WOODBIDGE TOWN COUNCIL ORAL PRESENTATION

ISH (6) – COASTAL GEOMORPHOLOGY

Wednesday 14 July 2021

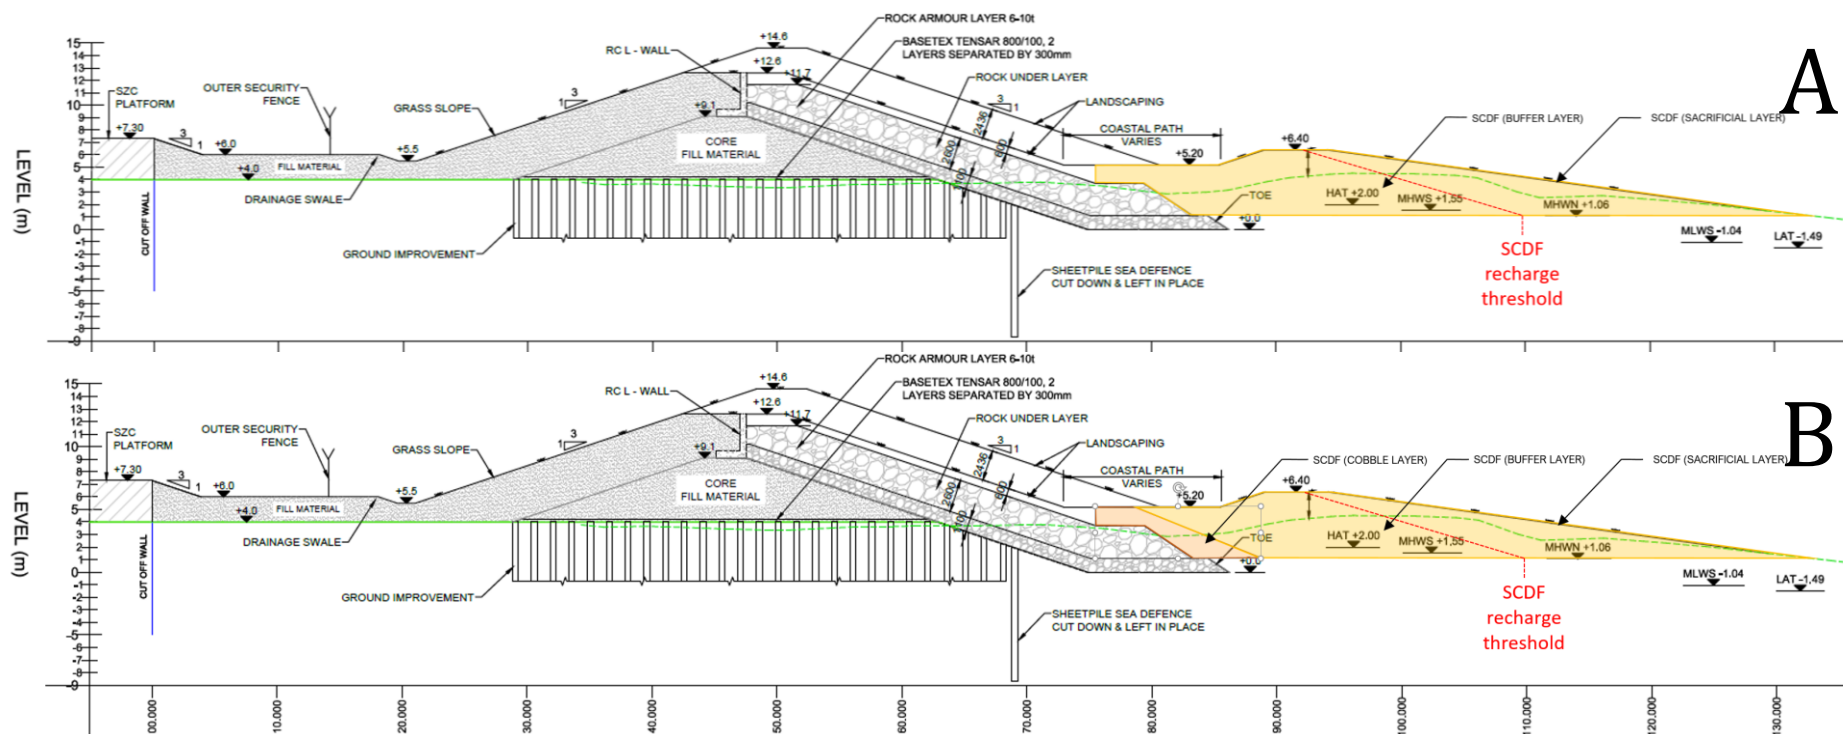
Mr. Patterson has raised the issue of the toe depth and extent and I would reiterate the point he raises, as it is crucial to the toe not being undermined so as to prevent unravelling of the rock slope. Further, as Mr. Patterson intimated the adaptive design includes a deeper and wider toe to be built, but in my view, as an engineer, it would be sensible to construct that deeper, wider buried toe now as construction when there are raised sea levels and possible limited, soft coastal defence would pose very considerable difficulties.

Onto the matter of foundations for the HCDF. There has been comment by East Suffolk Council about defence resilience needing to be considered and on the need for more detail to be given by the Applicant. Mr. Paul Collins has also raised the matter of a lack of detail. I have noticed, as have many IPs have, that there's been no development of the ground improvement details under the defence. It is that I wish to deal with now.

The Applicant has stated this improvement is to increase the strength of the peat which underlies the HCDF with respect to stability of the embankment. Raising an embankment on peat requires more than just considering traditional foundation and slope behaviour that one gets with traditional sand, silt and clay foundations. Peat has particular fundamental properties, it's low bulk weight, it's very low resistance to lateral spreading and it compresses significantly more than other soils under load, particularly in the long term. All these properties impact markedly on foundation behaviour on loading. It is quite common for fill placed on such ground to cause displacements of the peat towards the edges of an embankment area. Many ground improvement techniques struggle to cope with this type of foundation behaviour and can fail in their function due to displacements.

I have dealt with a number of litigation cases as an expert witness where such failures and displacements have occurred. This particular embankment has a very narrow crest compared to the length of the slopes and therefore has greater propensity for this type of lateral displacement behaviour. The impact of this is that the overlying embankment may well start to spread laterally if the technique doesn't work, and that the fill may start to effectively punch into the ground forming continuous type of failure leading to continuous significant settlement.

Finally, without the details of the ground improvement, the impact on coastal processes and geomorphology if the HCDF is removed, cannot be assessed and certain ground improvement techniques may well leave columns of hard material over the ground improvement footprint. Such material will not be able to be removed because of the way it is formed.

It is for the reasons I have referred to that I consider there is need for the ground improvement design to be provided by the Applicant so this can be looked at with regard to the coastal process and future geomorphology of the coast..
